**From:** Christopher Ashworth [REDACTED]  
**Sent:** Monday, 20 February 2017 4:45 PM  
**To:** Pilar Aberasturi  
**Cc:** Brendon Roberts  
**Subject:** SICEEP Darling Square - Mixed Use Community and Retail Building within the North Plot and Adjacent Public Open Space (SSD 7021)

### **SICEEP DARLING SQUARE - MIXED USE COMMUNITY AND RETAIL BUILDING WITHIN THE NORTH PLOT AND ADJACENT PUBLIC OPEN SPACE (SSD 7021)**

**Our Ref: R/2014/24/B**

NORTH PLOT AND DARLING SQUARE
FURNITURE PLAN

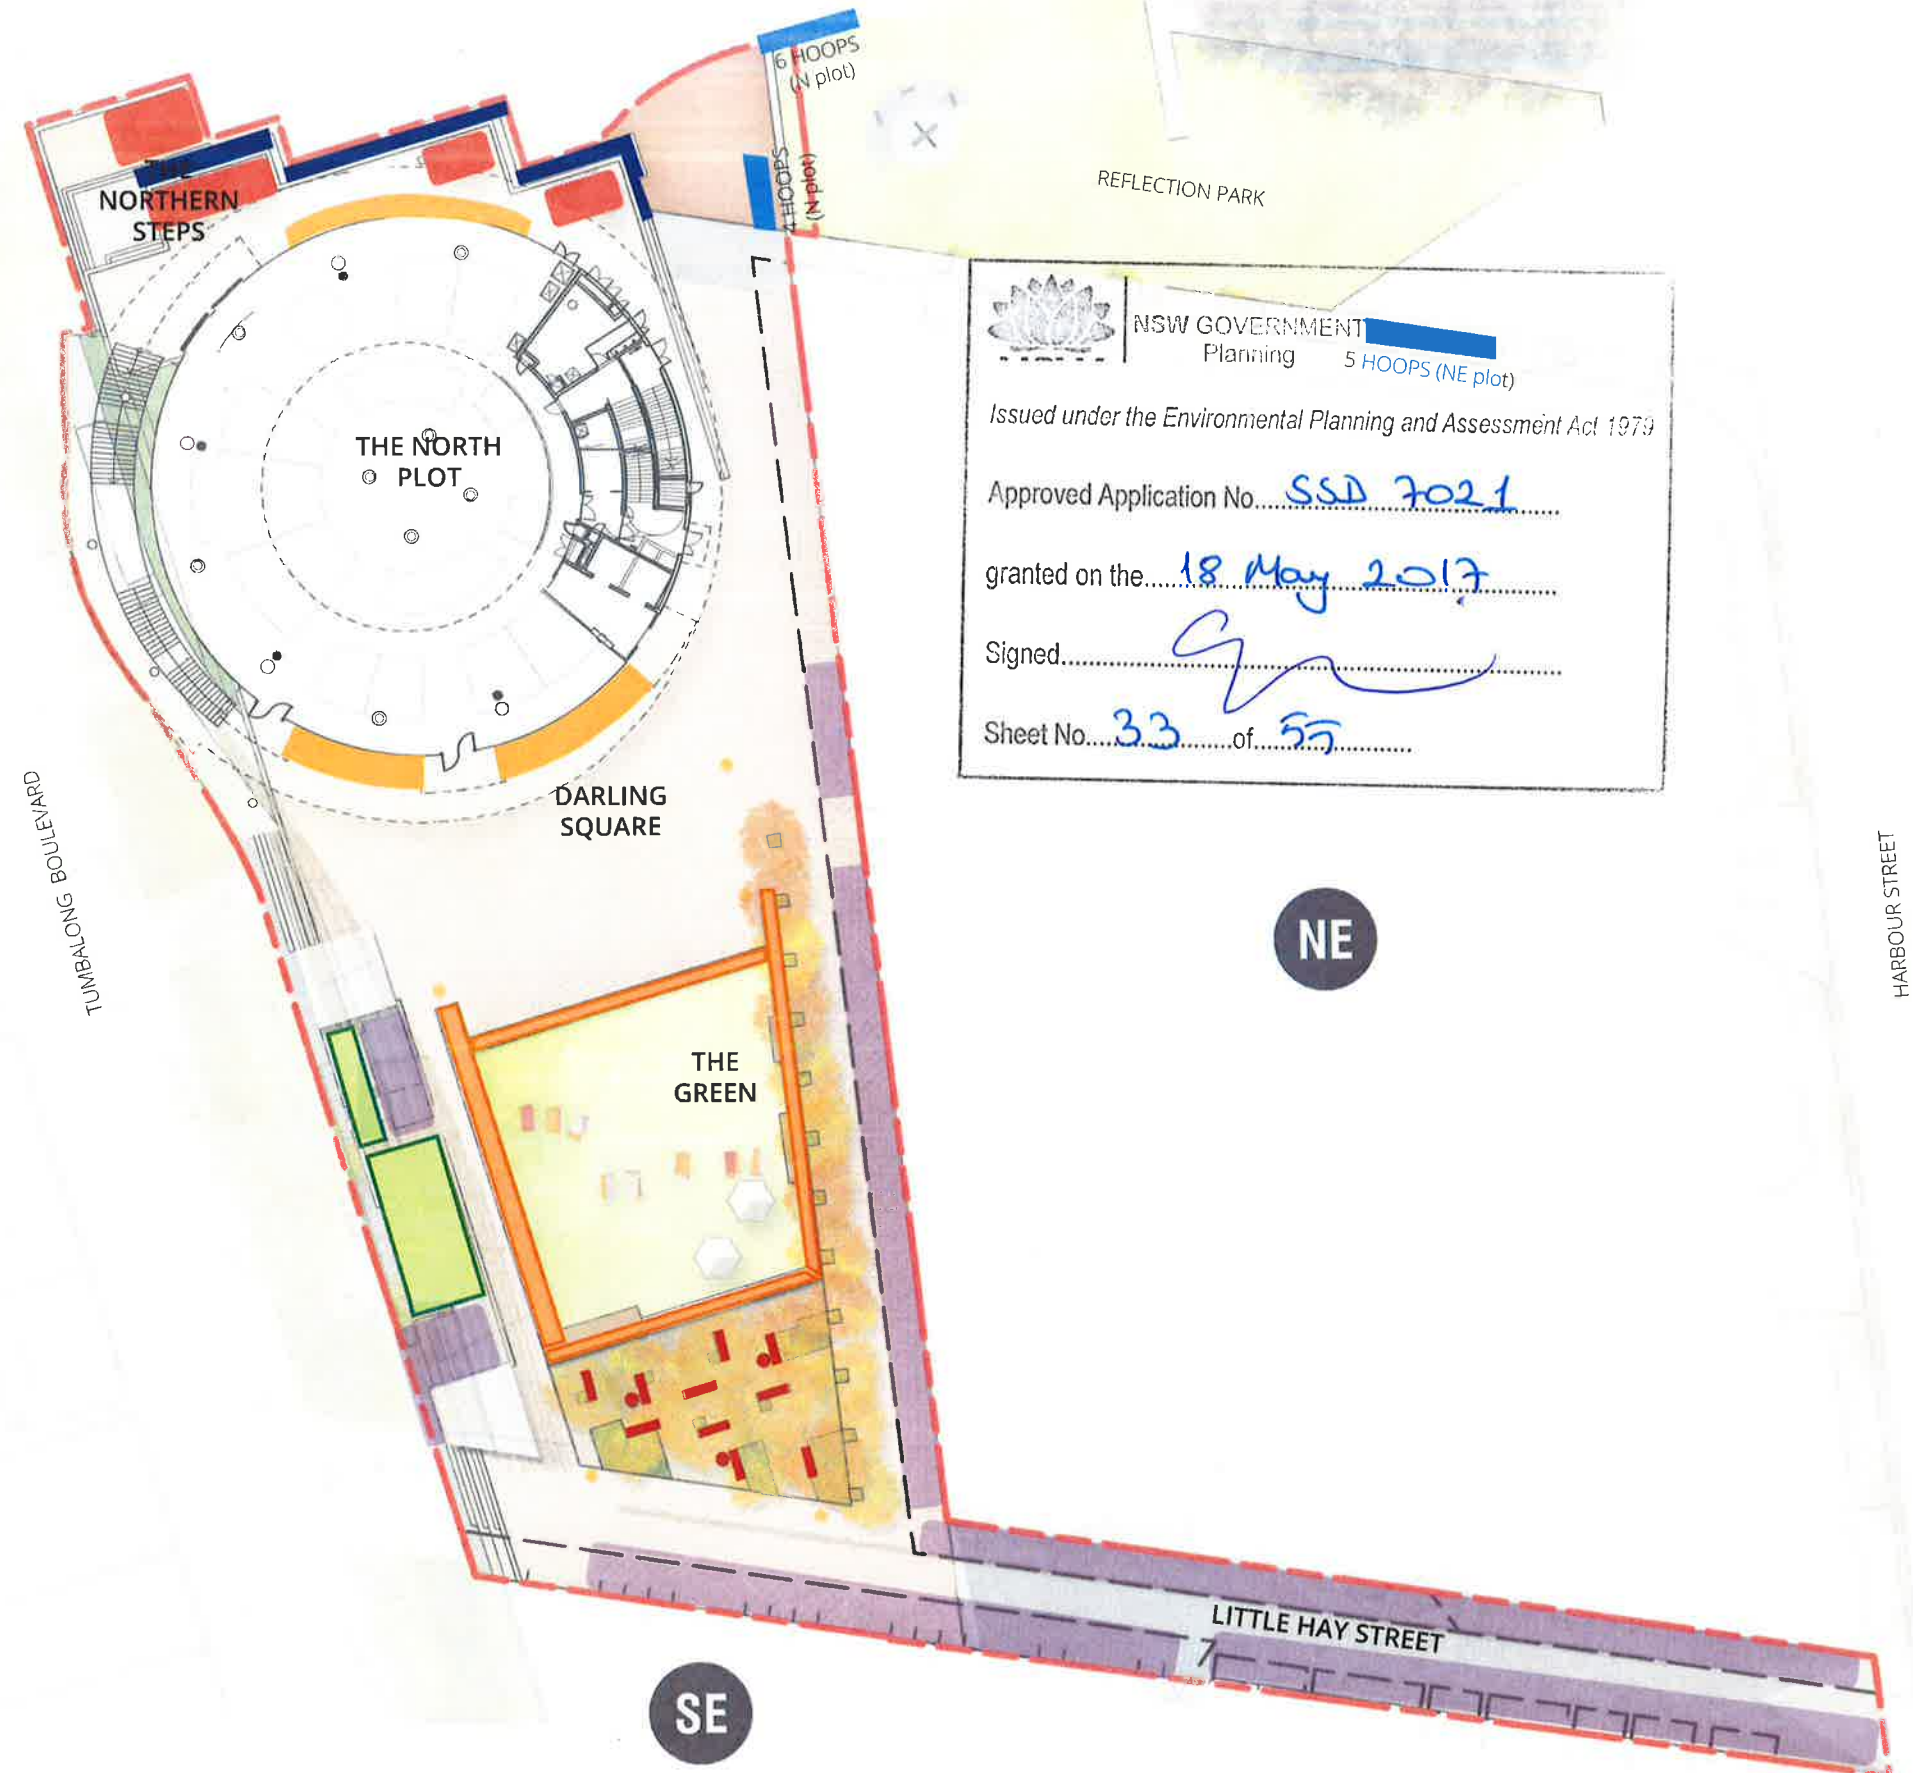
The City's concerns remain unaddressed. Variations within the palette should be minimised to achieve a cohesive outcome.
